Norwich to Tilbury Examination – Deadline 7.

Representation by the North-West and South-West of Chelmsford Parishes Group

Re: Applicant's Comments on any Further Information or Submissions received by Deadline 5 [REP6-114].

Figure 2: Designations

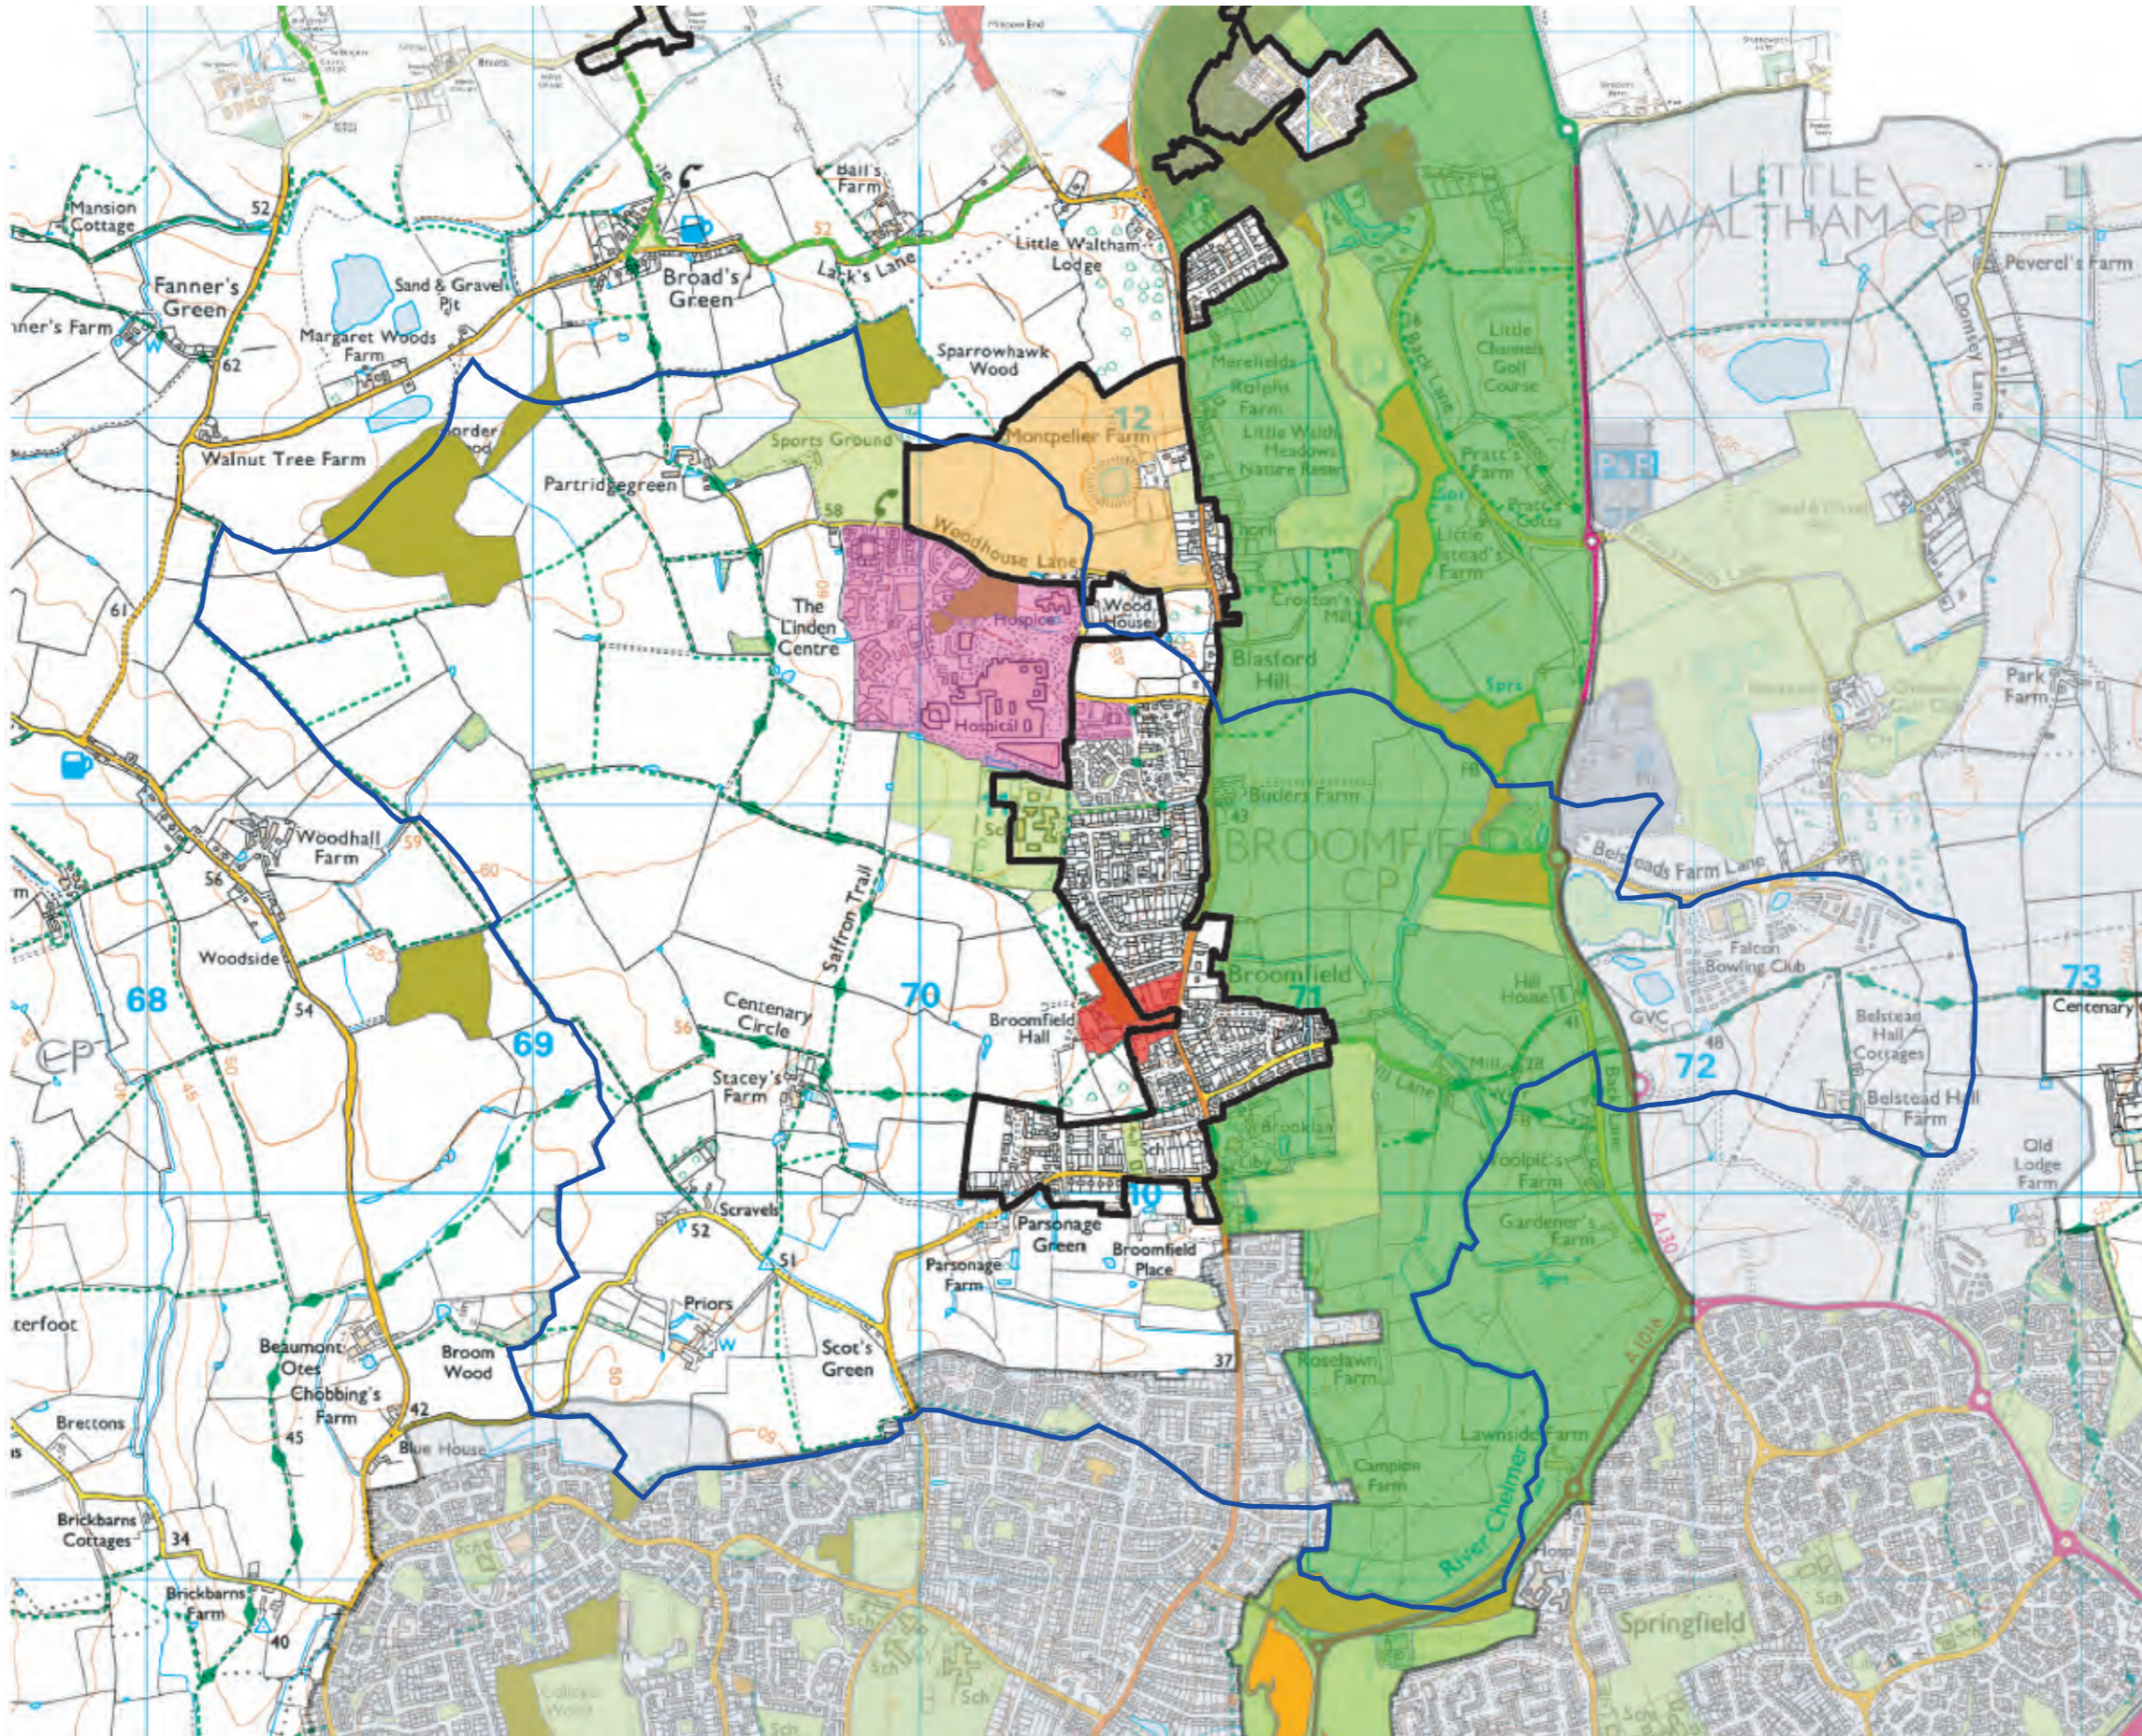
5. The Applicant and the Parishes Group are both in agreement that significant adverse effects extend beyond 500m from the proposed OHL in the area west of Broomfield. The Valued Landscape lies within this area (see annotated plan below). Given this, it can be concluded that the proposed development would indeed adversely affect the Valued Landscape west of Broomfield. However, this conclusion is not explicitly acknowledged by the Applicant.

6. Further, the Applicant has concluded a landscape value of low-medium adjacent to the area of Broomfield just over 1km from the proposals. However, the more detailed assessments of this area (such as the NP assessments referred to above) demonstrate that it has greater value and therefore higher sensitivity. Therefore, the Group holds that, even with this greater distance, the effects of the OHL on the area adjacent to Broomfield village would be significant adverse. The Applicant already agrees that sensitivity is moderate to high in LCA G2 – this does not suddenly cease at a line 1km from the OHL.

7. The Applicant states that *'there will be no direct landscape effects, such as loss or changes to landscape features within the Valued Landscape ...'*. However, this is to miss the point - indirect effects also give rise to significant adverse effects.
